CITY OF ALBUQUERQUE

November 20, 2017

RE: **2100 Osuna NE**
Grading Plan Engineer's Stamp Date 11/15/17
Drainage Report Engineer's Stamp Date: missing
Drainage File: E16D001

ENGINEER'S SEAL	2100 OSUNA	DRAWN BY WCWJ
DAVID SOULE REGISTERED PROFESSIONAL ENGINEER 14522	GRADING AND DRAINAGE PLAN	DATE 8-07-17
8/1/17	Rio Grande Engineering 1606 CENTRAL AVENUE SE SUITE 201 ALBUQUERQUE, NM 87106 (505) 872-0999	21724-LAYOUT-3-24-17
DAVID SOULE P.E. #14522		SHEET # —
		JOB # 21724

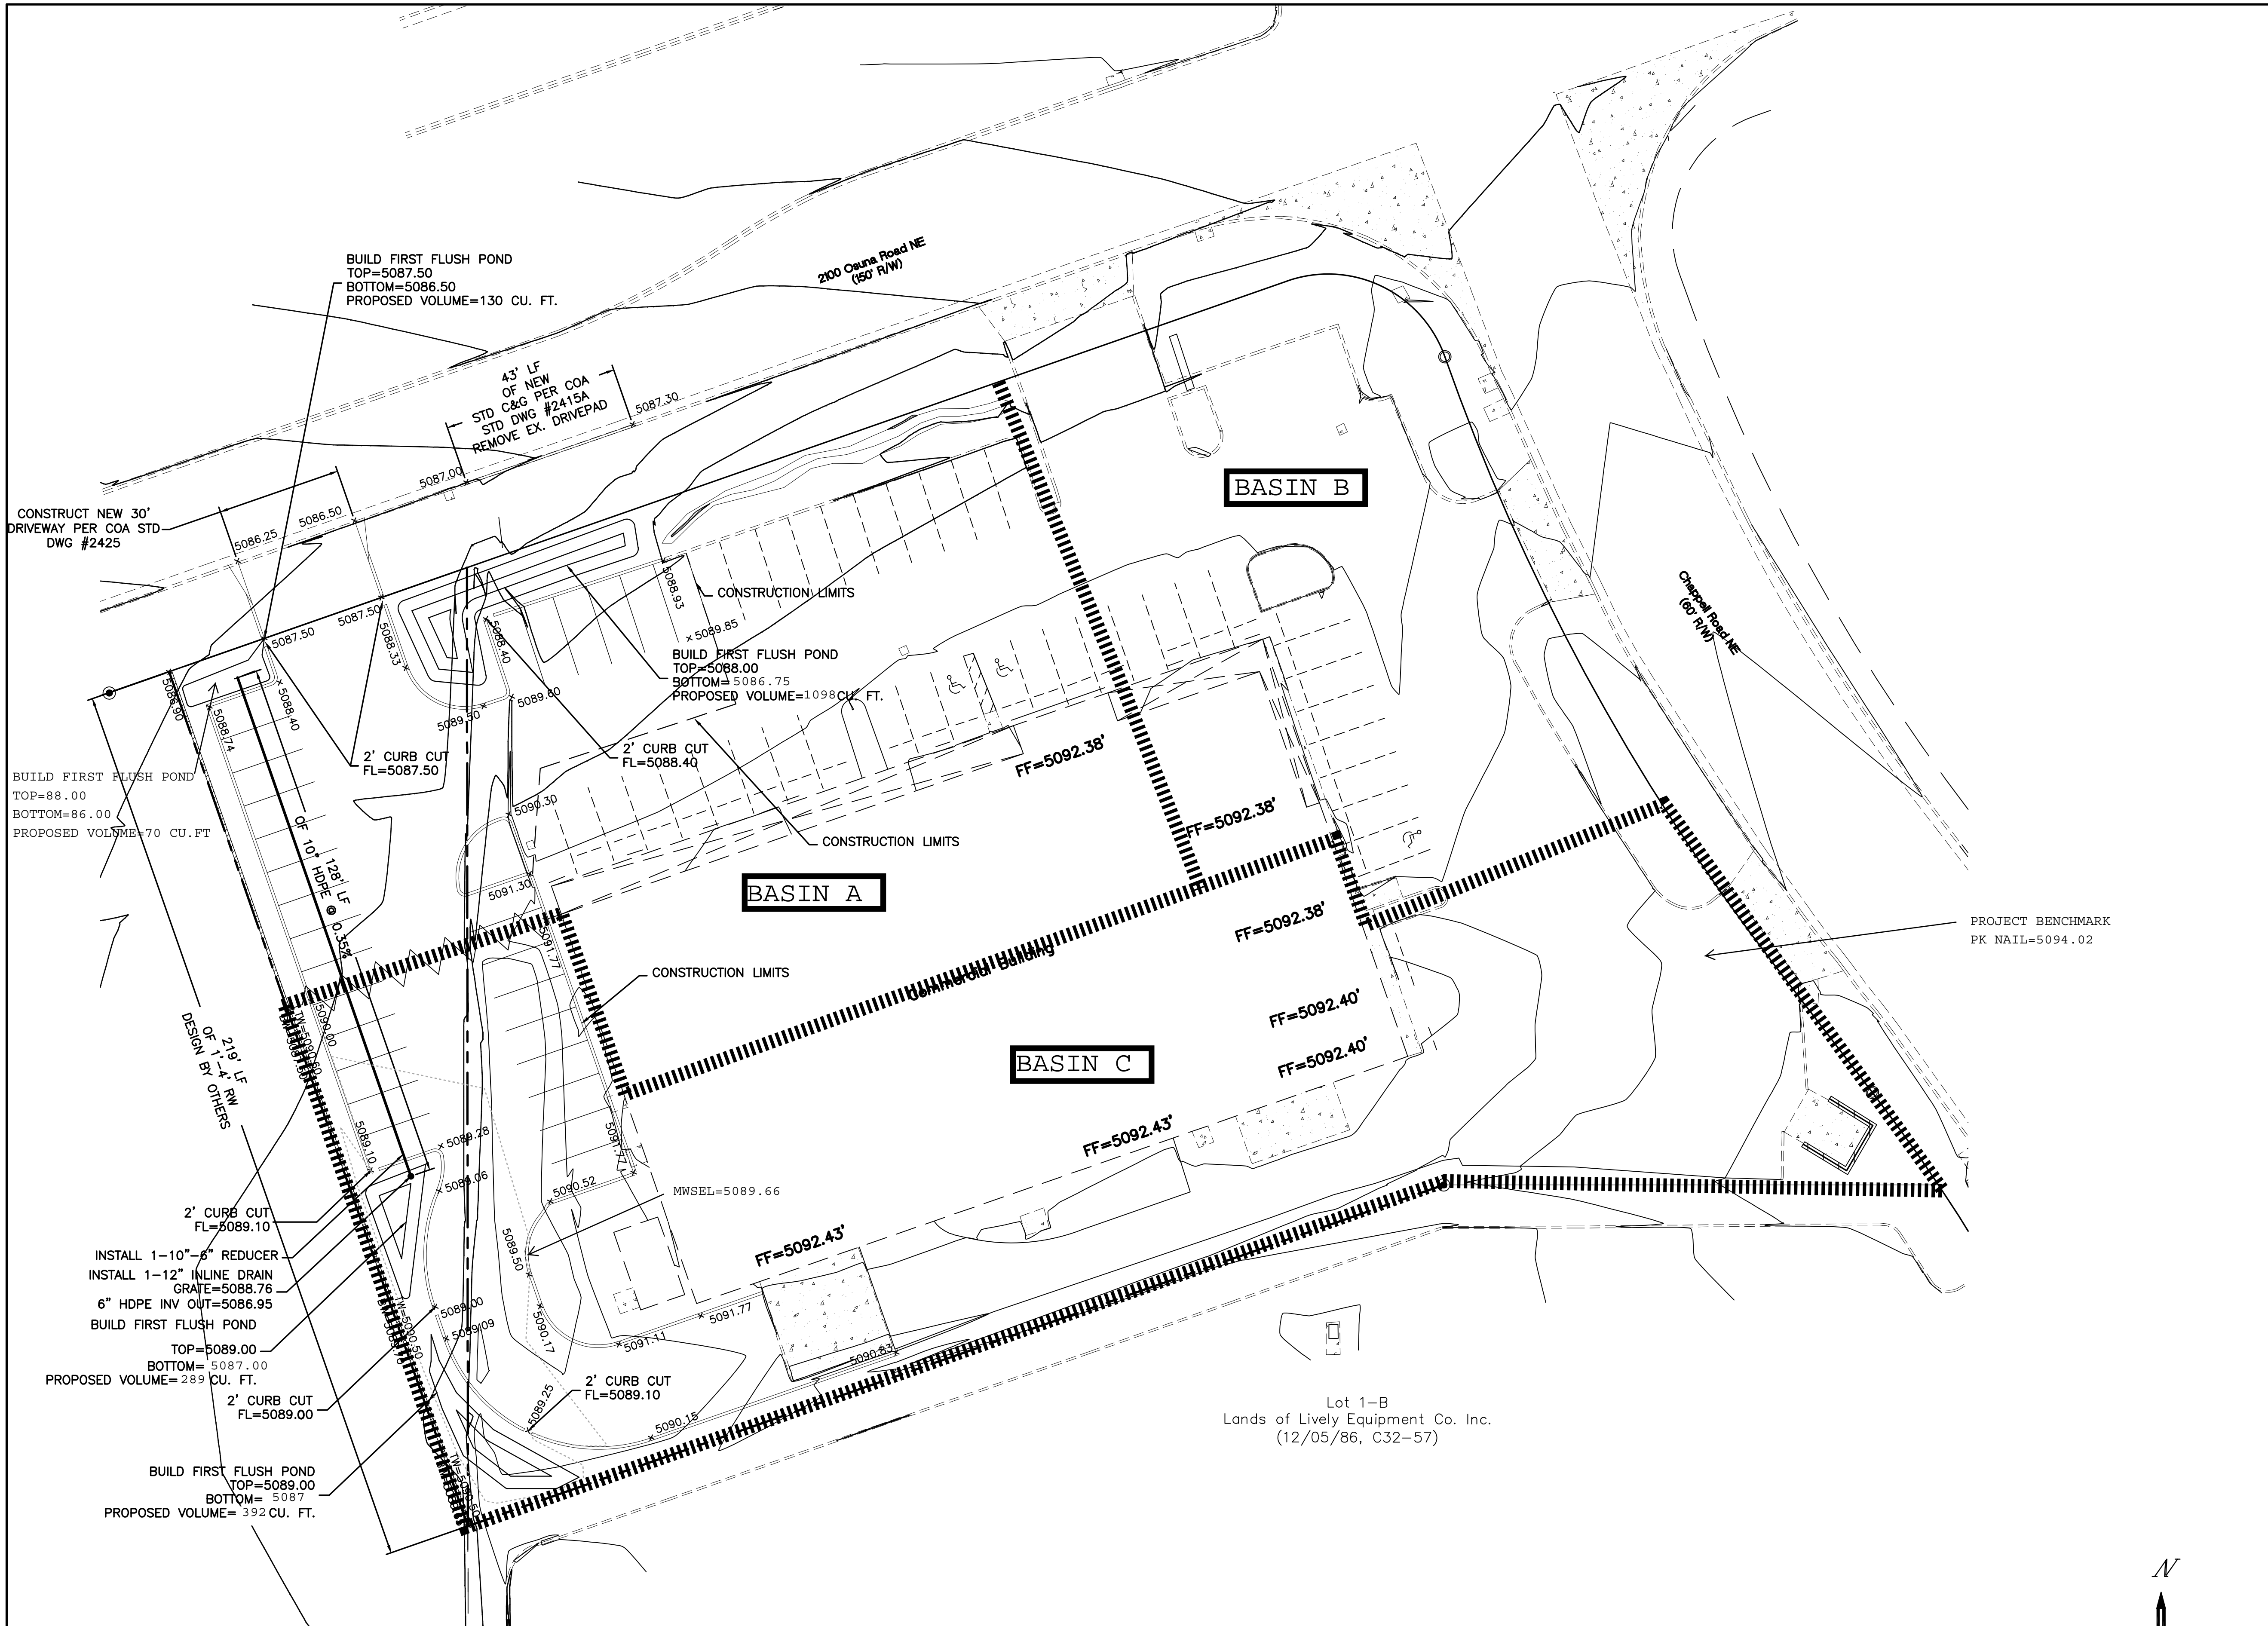
1. Provide a section view through the retaining wall (including dimensions, lease line, and basis of establishing the lease line).
